Development Facilitation Team (DFT) – Review Comments

DRB Project No: PR-2022-007712 Date: 07/12/2023 Agenda Item: #1 Zone Atlas Page: C-11

Application For: SD-2023-00127-Final Plat (DHO)

DRB Project Number: 2022-007712
Rosa Parks – Volcano Cliffs Unit 26

DOCH 2024014448
 SOUTH PLAT OF TRACT 1-A AND TRACT 1-B, BLOCK 2, VOLCANO CLIFFS SUBDIVISION, UNIT 26
 BERNALILLO COUNTY, NEW MEXICO

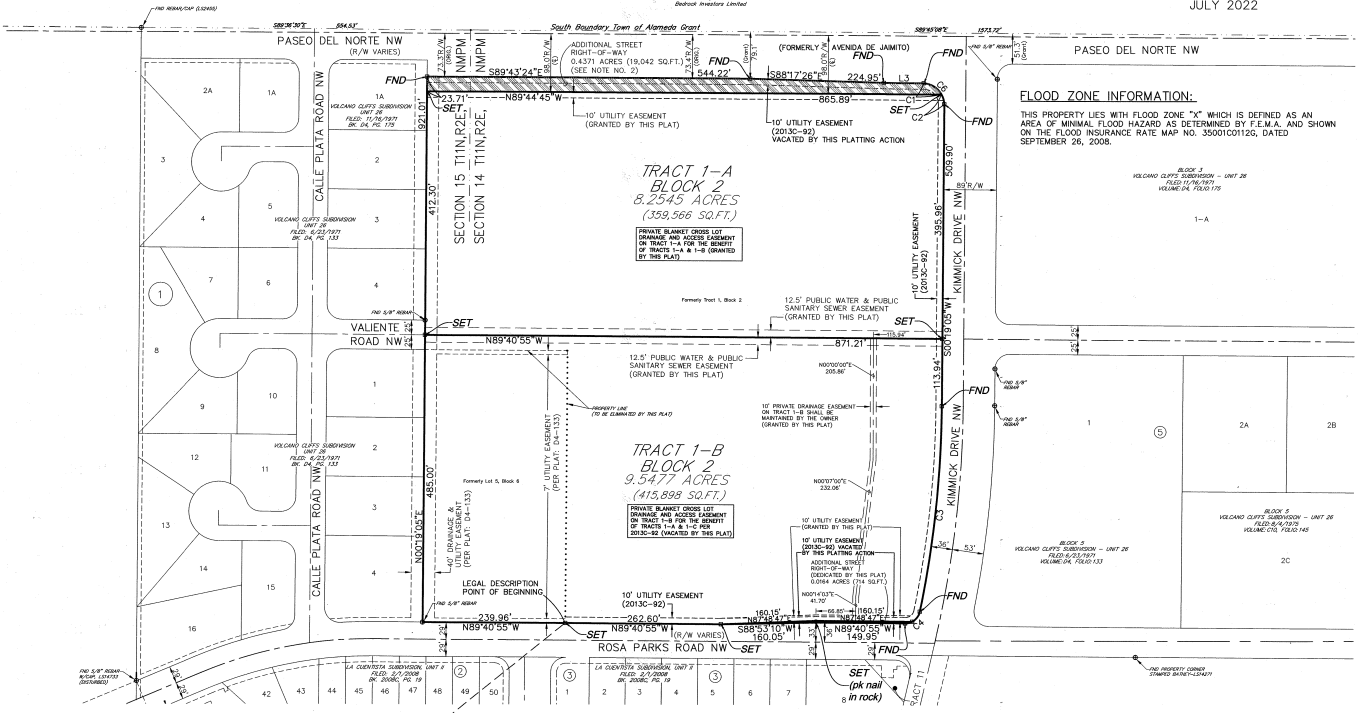
1. Availability Statement 220512R along with Development Agreement R-22-25 provides conditions for service. The infrastructure list has been approved and financial guarantee is in place.
2. Add the following note on the plat when easements are being granted for public water and/or public sanitary sewer infrastructure.

- Project and application numbers must be added to the Plat.
- The DXF file must be approved by AGIS, and the approval email from AGIS must be submitted prior to final sign-off from Planning should the Plat be approved by the Development Hearing Officer.
- All public infrastructure along Paseo del Norte must be under a Procedure C Infrastructure Improvements Agreement (IIA) rather than a Procedure B IIA (per the IIA submitted with this Final Plat submittal). A separate Infrastructure List exclusively featuring the public infrastructure along Paseo del Norte must be submitted prior to final sign-off of the Final Plat.
